NC DEPARTMENT OF  
**HEALTH AND  
HUMAN SERVICES**

August 20, 2025

RE: 7-Eleven  
1360 NC 24-87  
Cameron, NC 28326

This letter acknowledges review of plans for the remodel of the above referenced establishment. The original plans dated 06/06/25, revised application, and specifications, including email correspondence are conditionally approved with the following comments:

P1.0

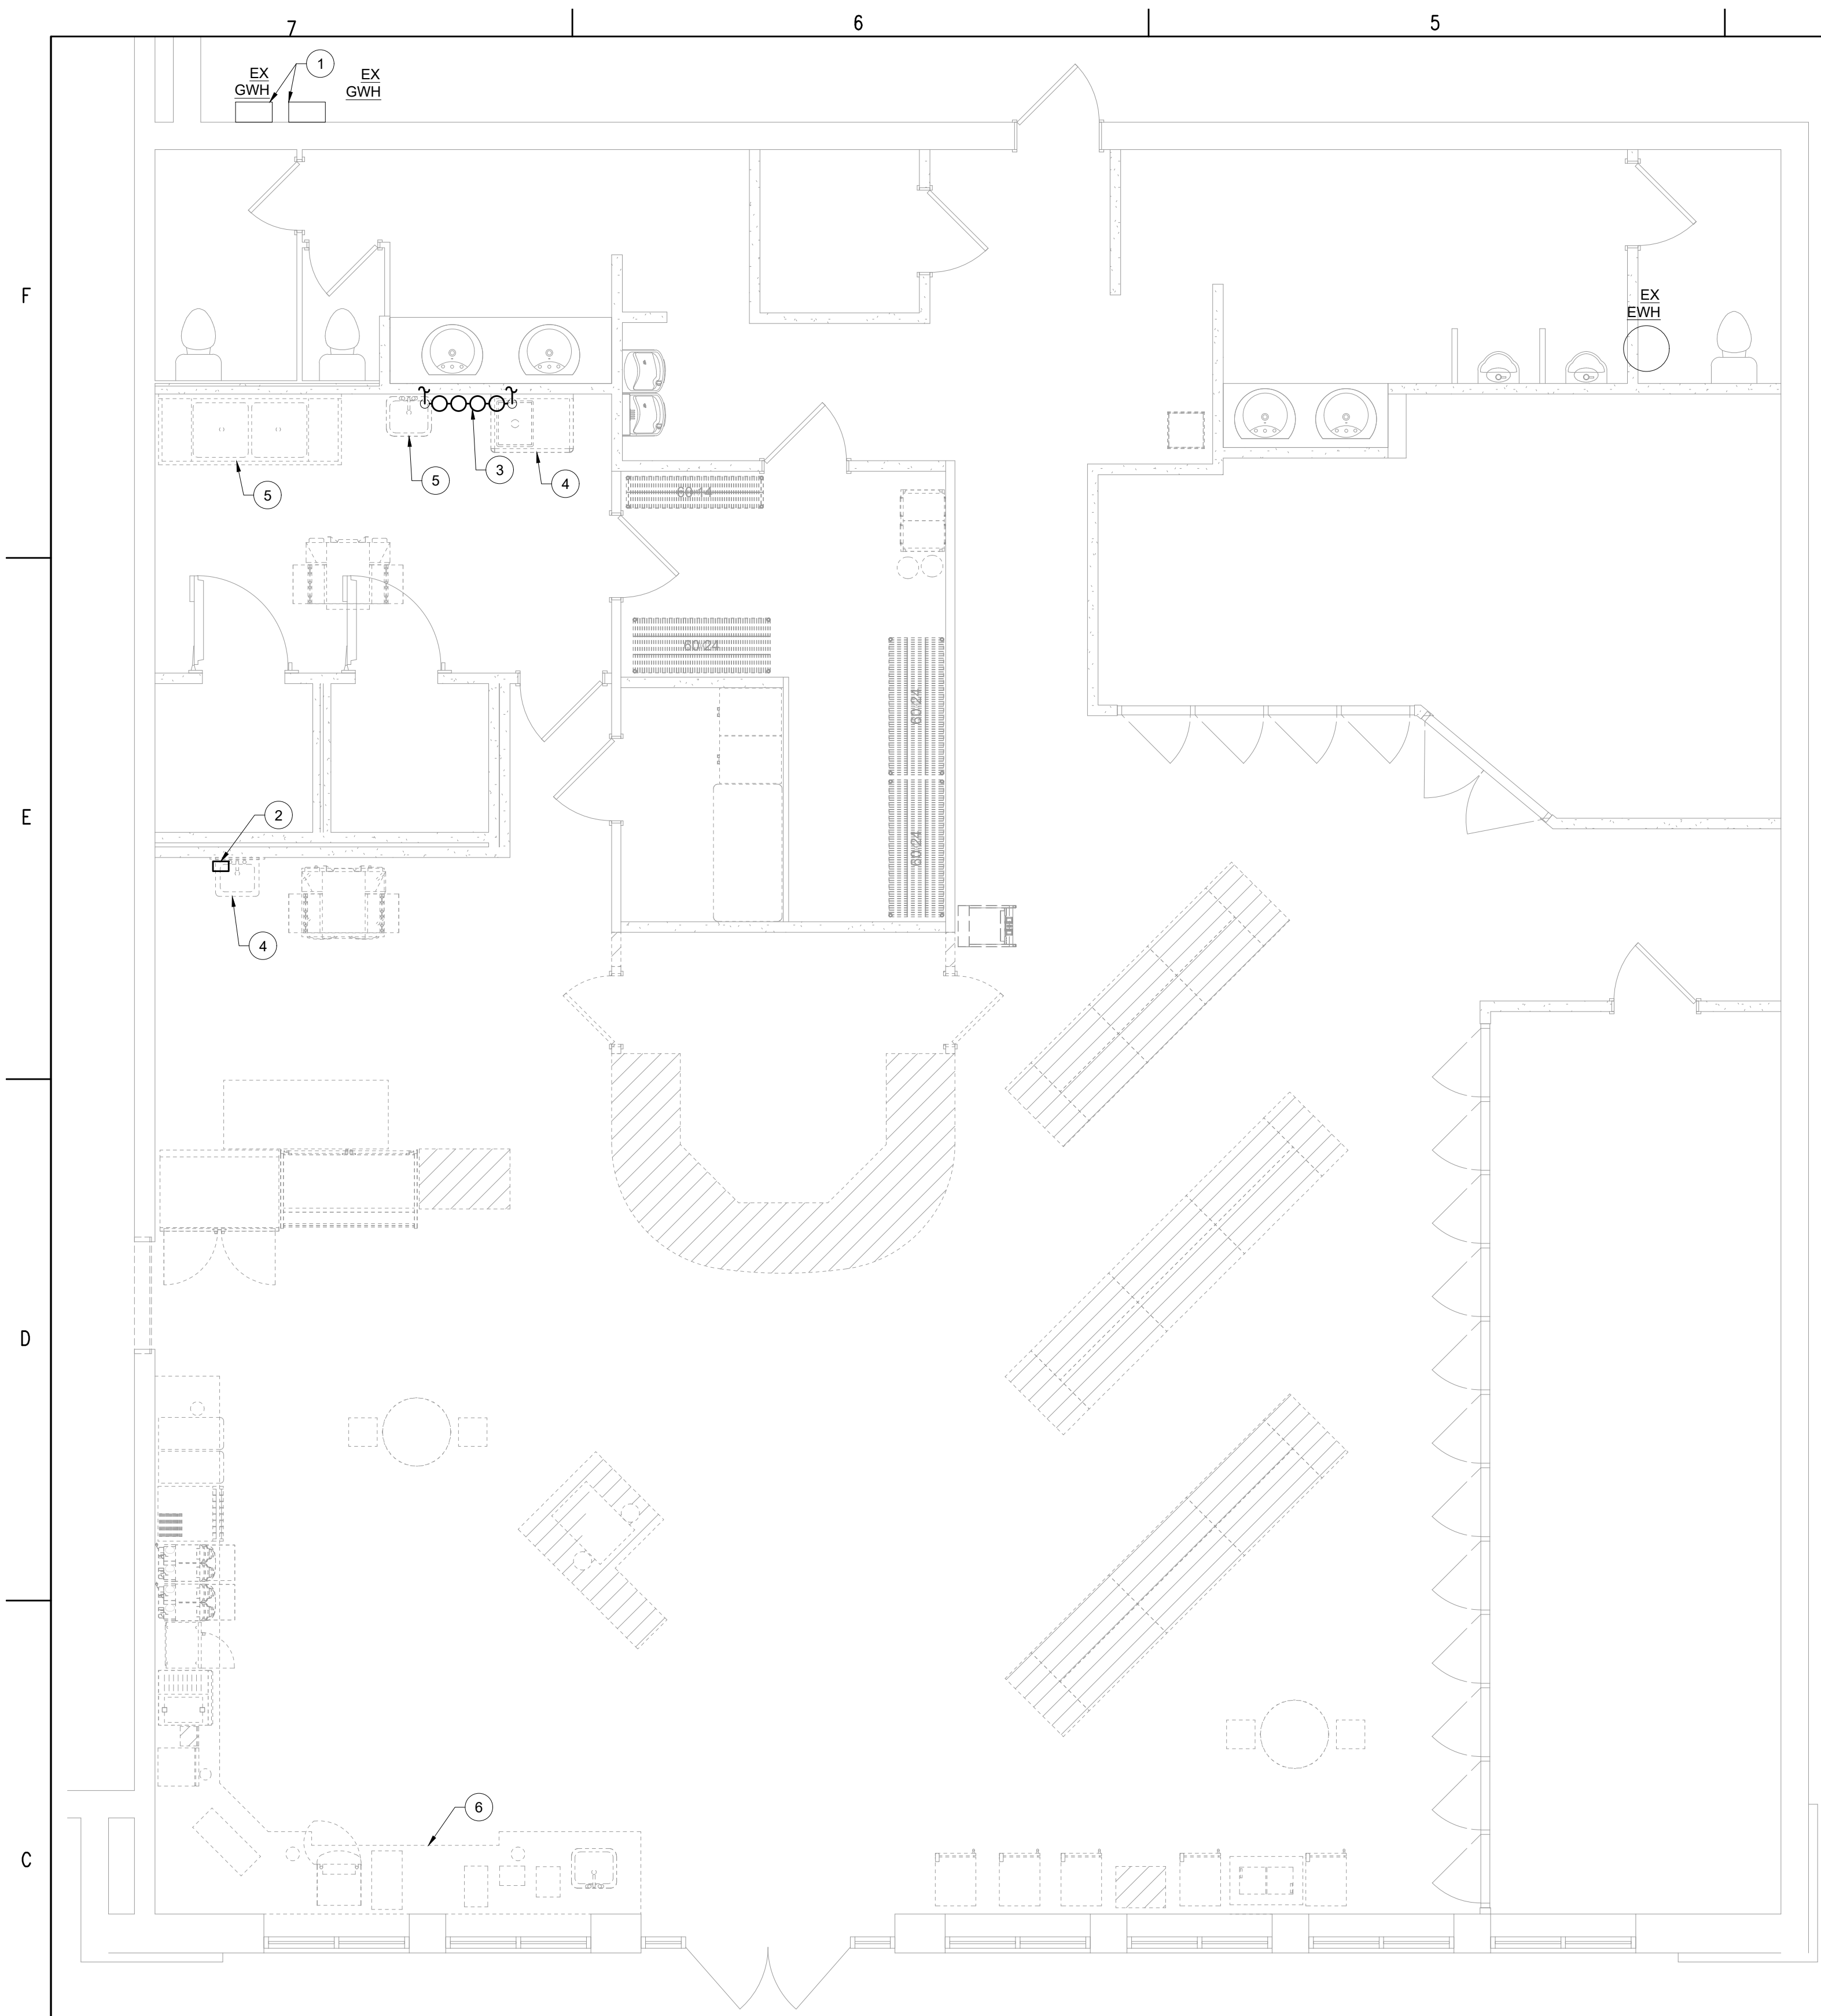
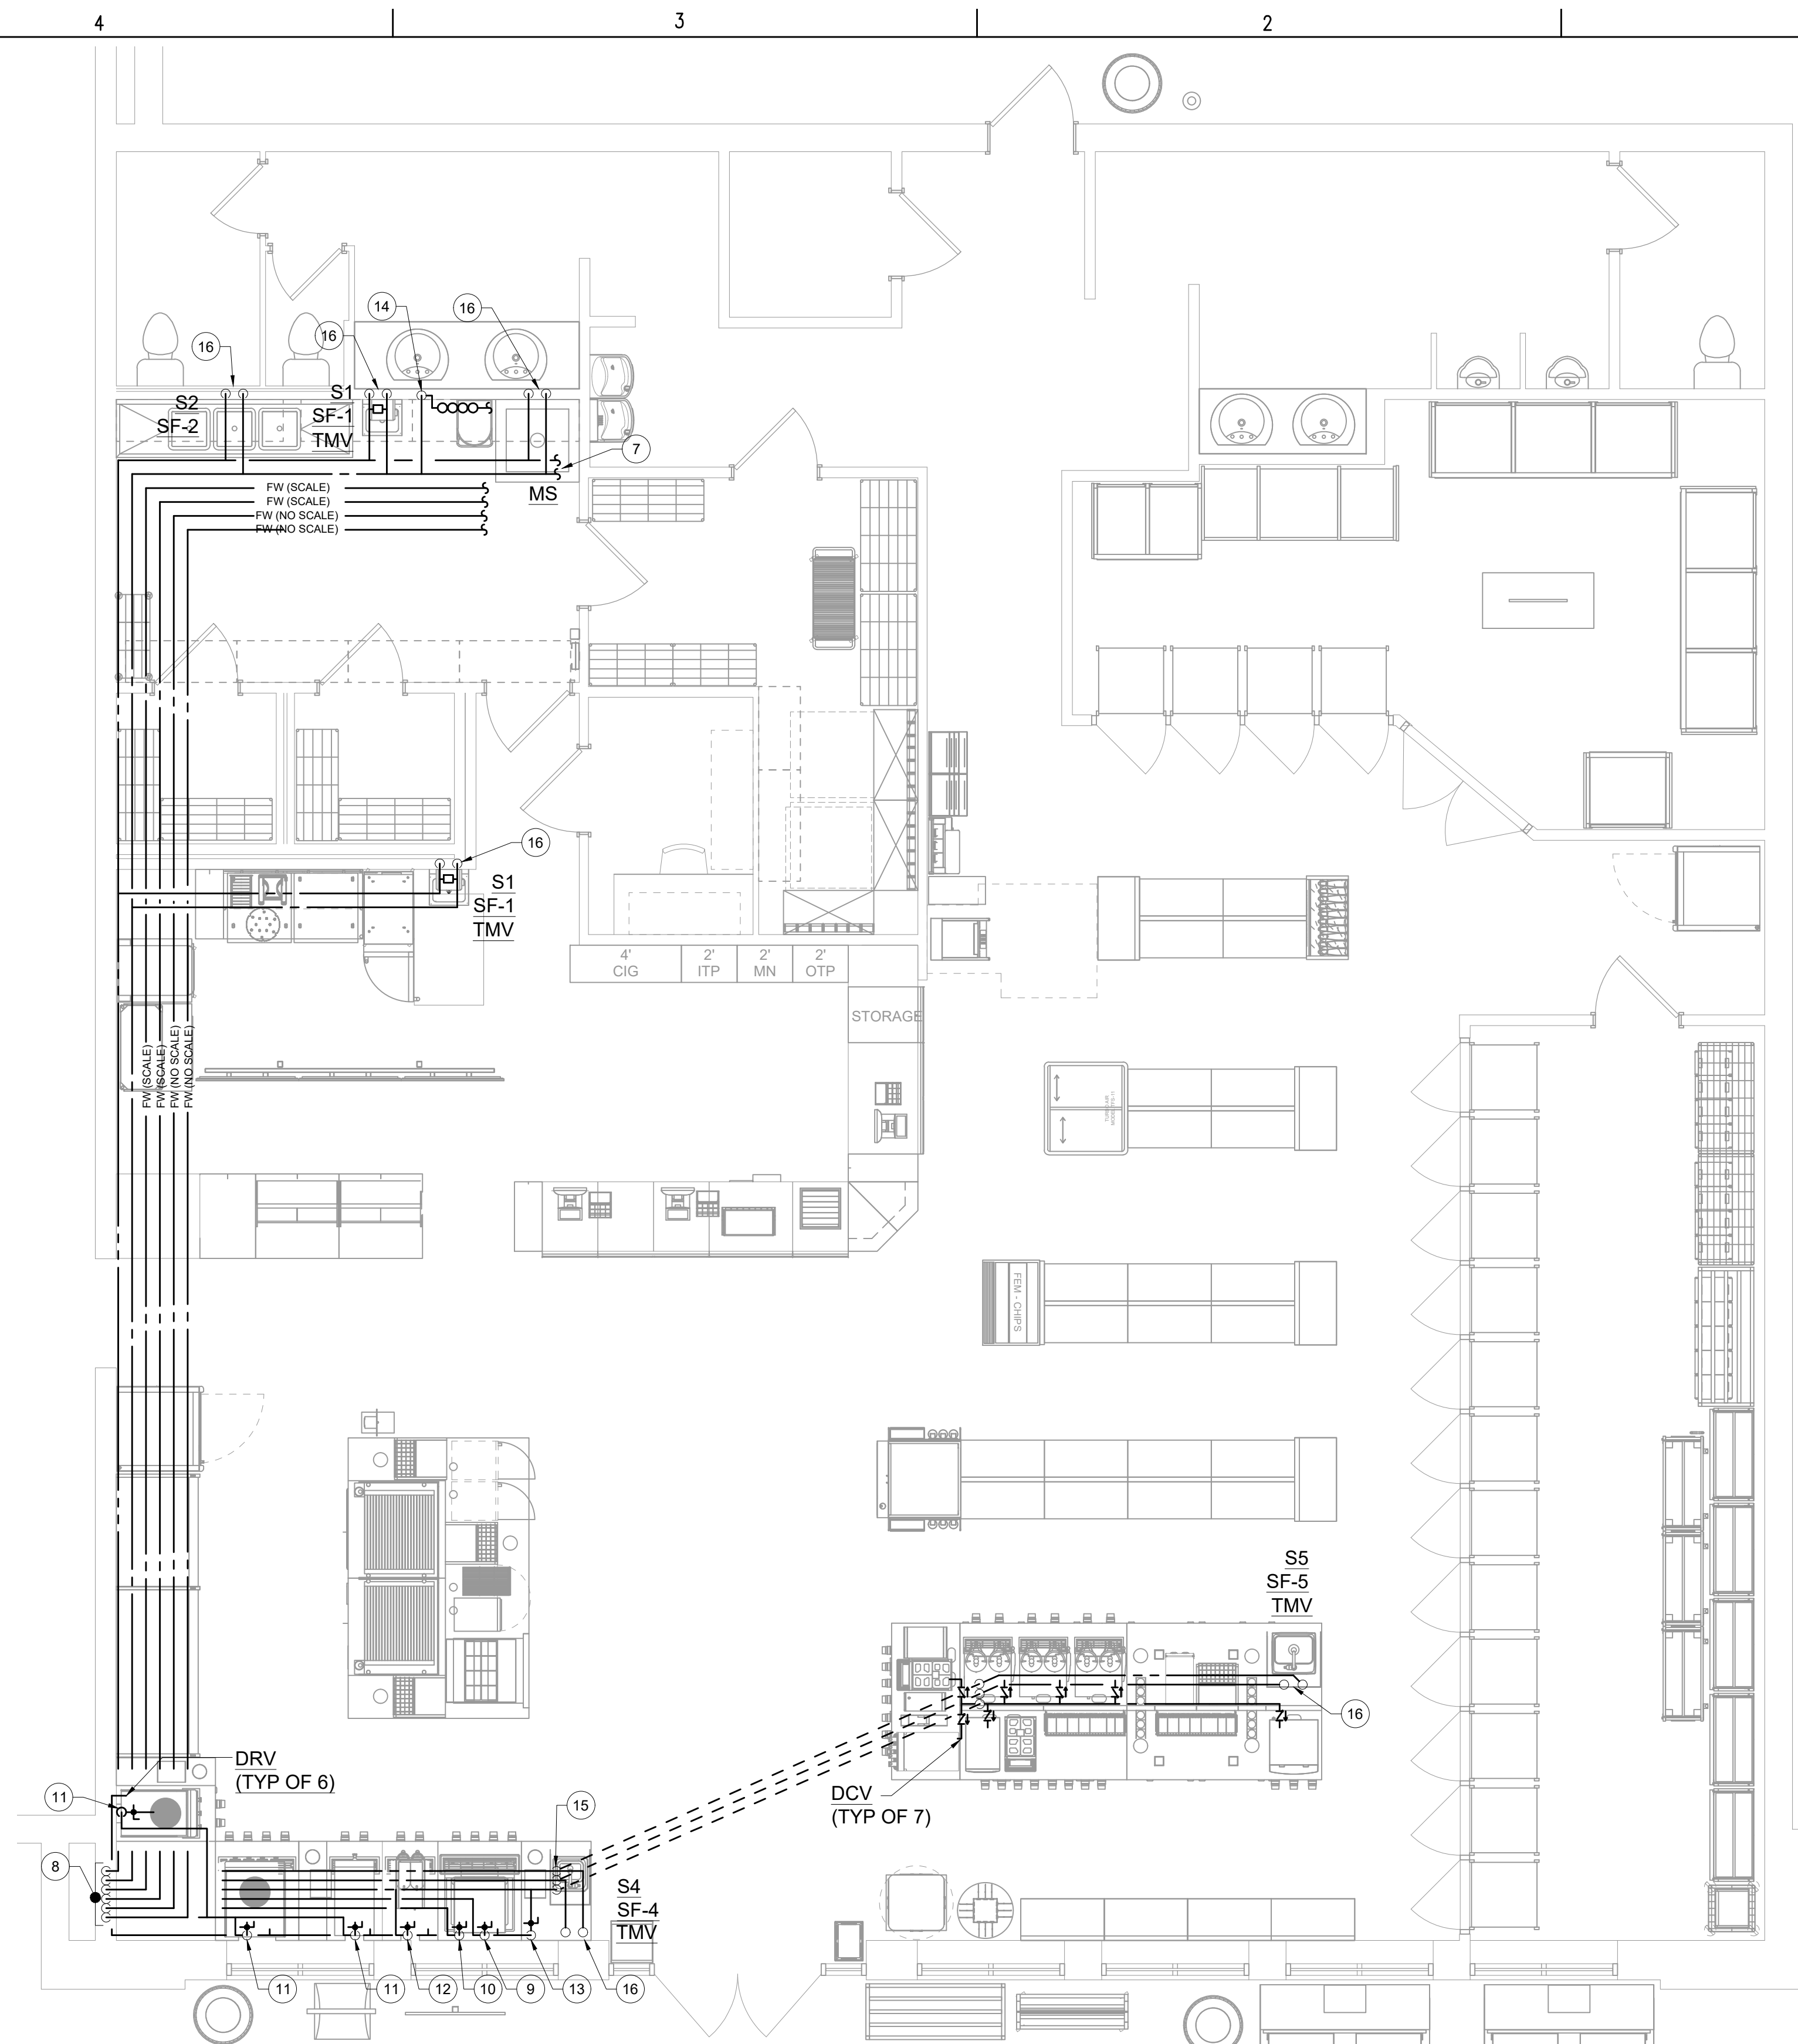
4. Plumbing must comply with all applicable plumbing regulations. These shall comply with Parts 5-1 and 5-2 and Parts 6-3, 6-4, and 6-5 of the Food Code. The Drain Piping Plan on sheet P1.0; Domestic Water Piping Plan on sheet P1.1, and P2.0; Plumbing Details and Schedules plan sheet are conditionally approved with the (2) 199MBH tankless water heaters as noted on sheet P2.0, and on the revised application. It is understood with the acceptance of engineered sealed drawings, if the design of

the hot water heating system does not meet the required hot water demand during peak periods; the hot water heating system will be modified or replaced to meet requirements.
